This response is from and on behalf of The Colne Valley Regional Park

This revised application is an improvement on that previously proposed to which we objected strongly. We recognise the unique circumstances that have led to this application and have great sympathy for HOAC's position, but we are concerned that the application as currently submitted still harms the status of the Mid Colne Valley SSSI contrary to National and Local planning policy and conflicts with the objectives of the CVRP. We are therefore disappointed that The London Borough of Hillingdon has not sufficiently take our previous concerns and that of other bodies, including statutory, into account when revising this application.

Project
HWSFAC Broadwater Lakes
 Drawing Title
Landscape masterplan - peninsula

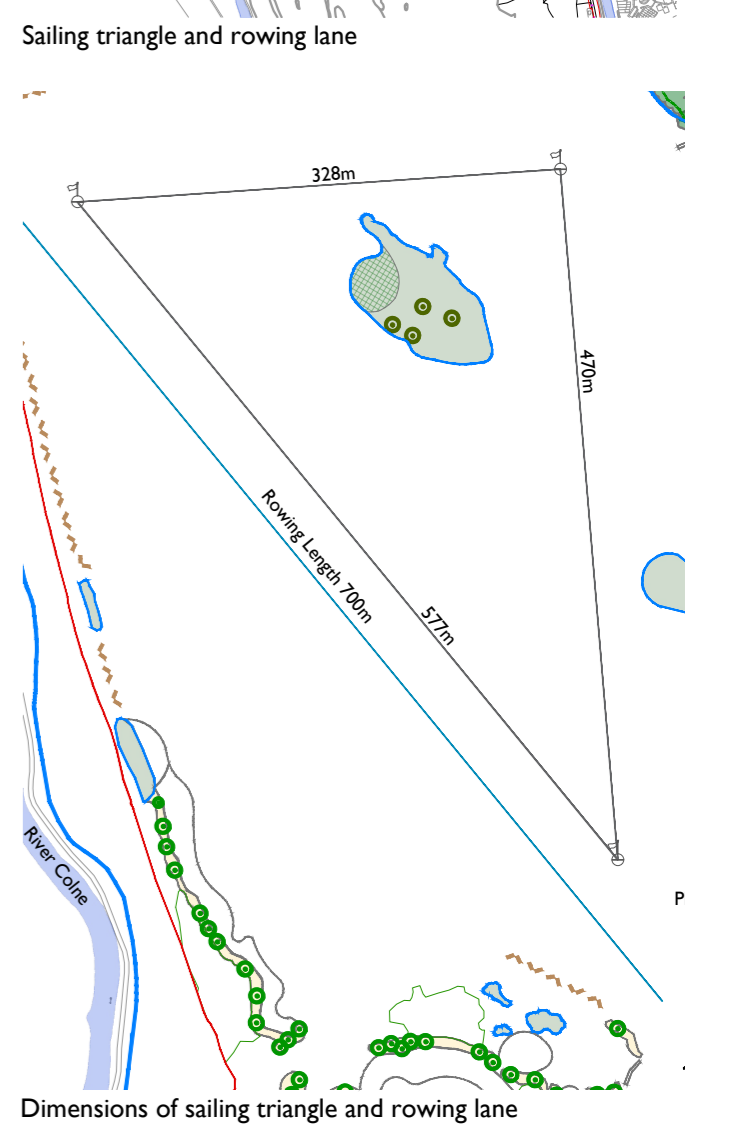
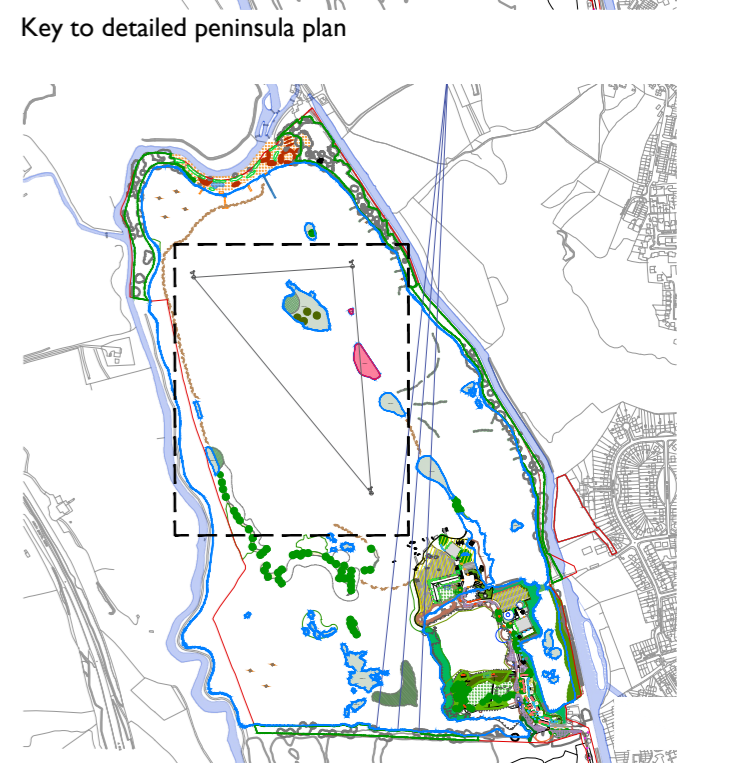
- Other concerns are the loss of woodland to create the activity centre and recreational buildings; intensification of activities - 7/7 instead of twice weekly for the existing sailing club; increased lighting and traffic (although limited to the southeast corner). All of these would have a negative impact on the biodiversity but it will particularly affect the bats.

- Some of the islands would be removed including one covered in Japanese knotweed so this could be a neutral effect.
- The application is mistaken in assuming the land where the development is proposed is Grey Belt - land within a SSSI and with possible flooding concerns is specifically excluded from Grey Belt definition and therefore is fundamentally unsuitable for development. This land is not Grey Belt.

Figure 9: Existing and Proposed Sailing Areas

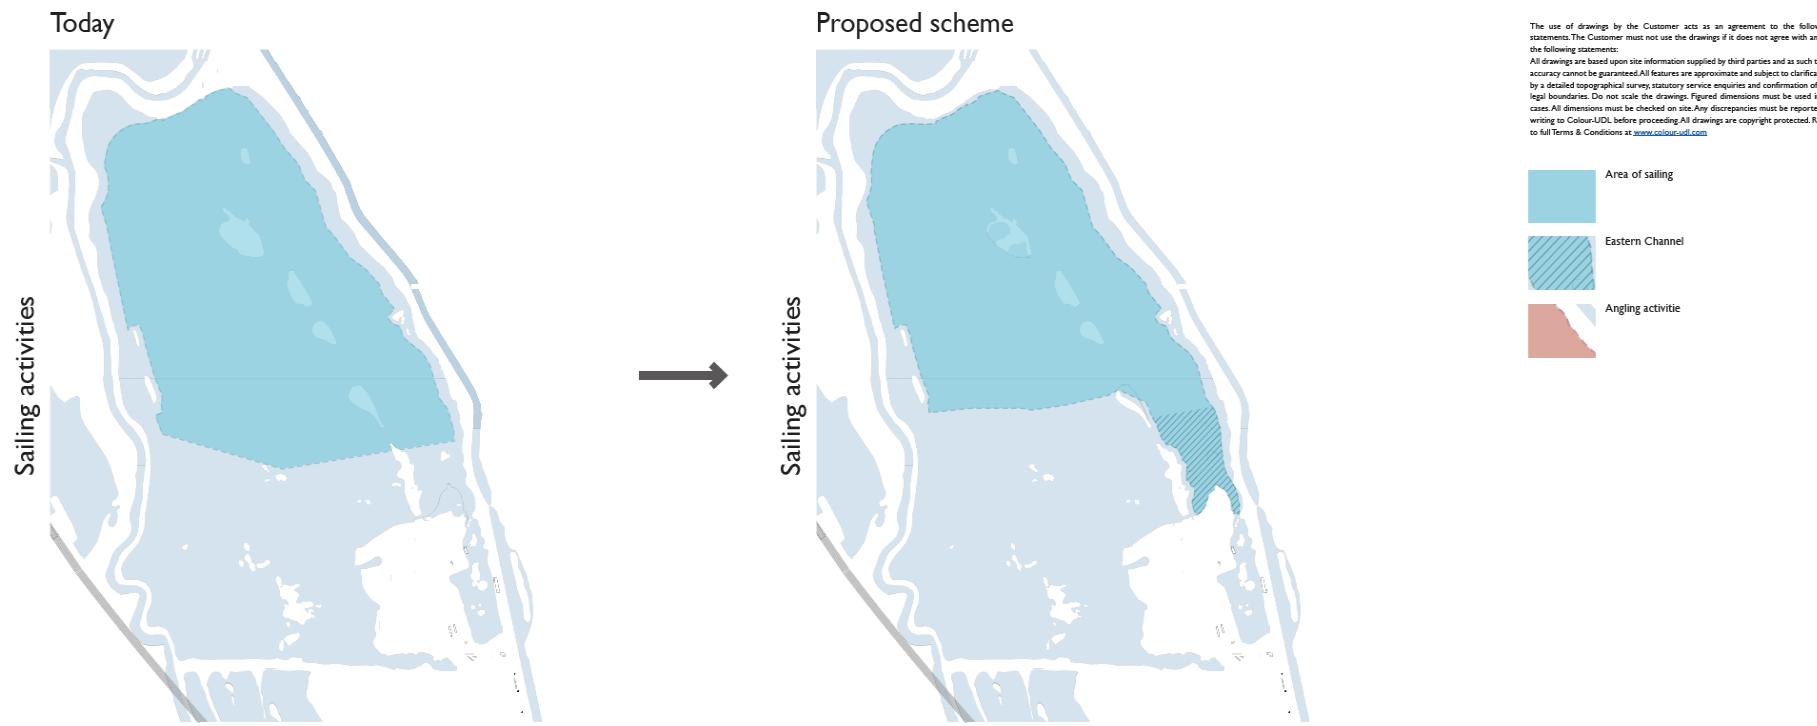
- Potential improvements to the previous scheme are the demolition of the current Broadwater sailing club ensuring the restoration of the northern part of the lake and removing or downgrading the access road. If the decision is made to approve then restrictions should also be imposed to prevent sailing on the western side of the lake and limit activities to the eastern side where the facilities are. I have compared the size (if sailing restricted to the eastern

portion) with Bury Lake at the Aquadrome and at HOACs previous location and they are similar.
